From: Ayub Patel <ayubpat@gmail.com>
Sent: 01 May 2025 12:09
To: DC Admin
Subject: Comments on Application 2025/90439 and 2025/90441 which is for the conversion of existing listed church on Vicarage Road, Dewsbury, WF12 9PD into 2 dwellings and forming a new residents car park
Attachments: Attachment 3- relocation of proposed new trees (2).PNG; Attachment 1- showing rising car park and misleading ground level (2).PNG; Attachment 2- new proposed trees are too close to my property (1).PNG

Comments on Application 2025/90439 and 2025/90441 which is for the conversion of existing listed church on Vicarage Road, Dewsbury, WF12 9PD into 2 dwellings and forming a new residents car park

PROPOSED SITE PLAN SCALE 1:100

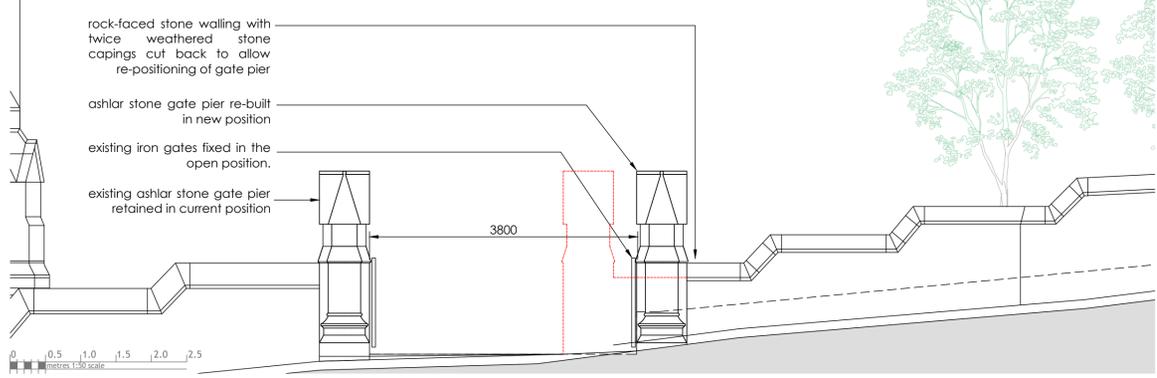
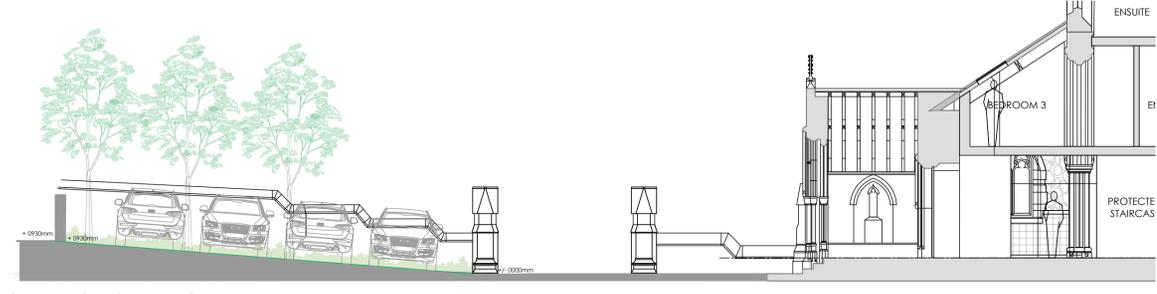
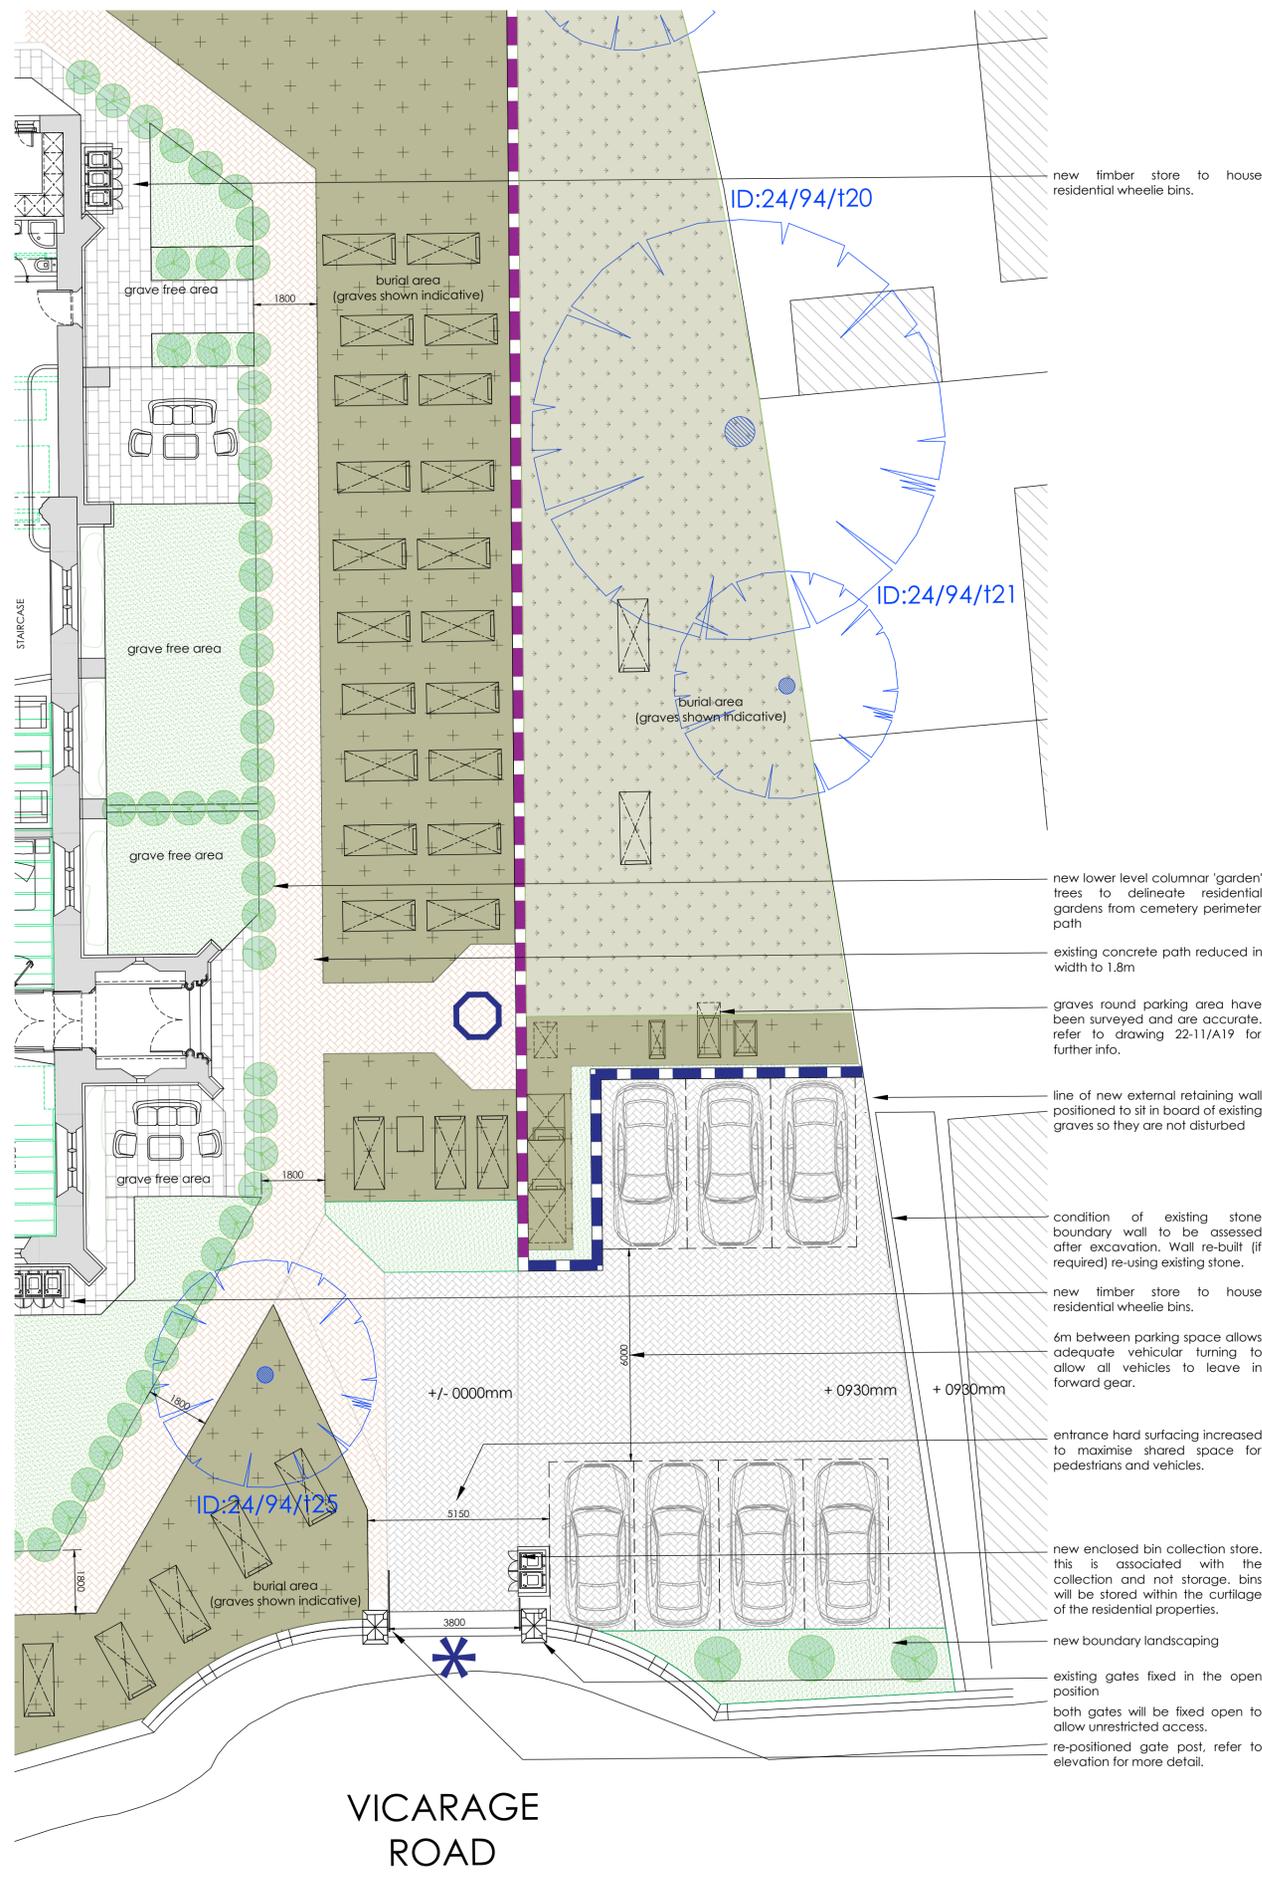
1. The car park which is directly behind my property shows that it (the car park) is rising towards my property (**see attachment 1**). I object to this because the cars will appear at roof level from my garage. The ground must be excavated so that it is flat.

2. Also, the plan (**see attachment 1**) is misleading because the wall behind my property is a retaining wall. My ground level is a lot lower. If the car park is not flattened to my ground level, there would be immense pressure on the wall with the weight of 7 cars.

4. I object to the replanting of trees in the position marked (**see attachment 2**) because the trees are too close to my property and in time, there is a high probability that the foundation of my house will crack or the walls will crack, and I would have difficulty in insuring the property with new trees in such close proximity.
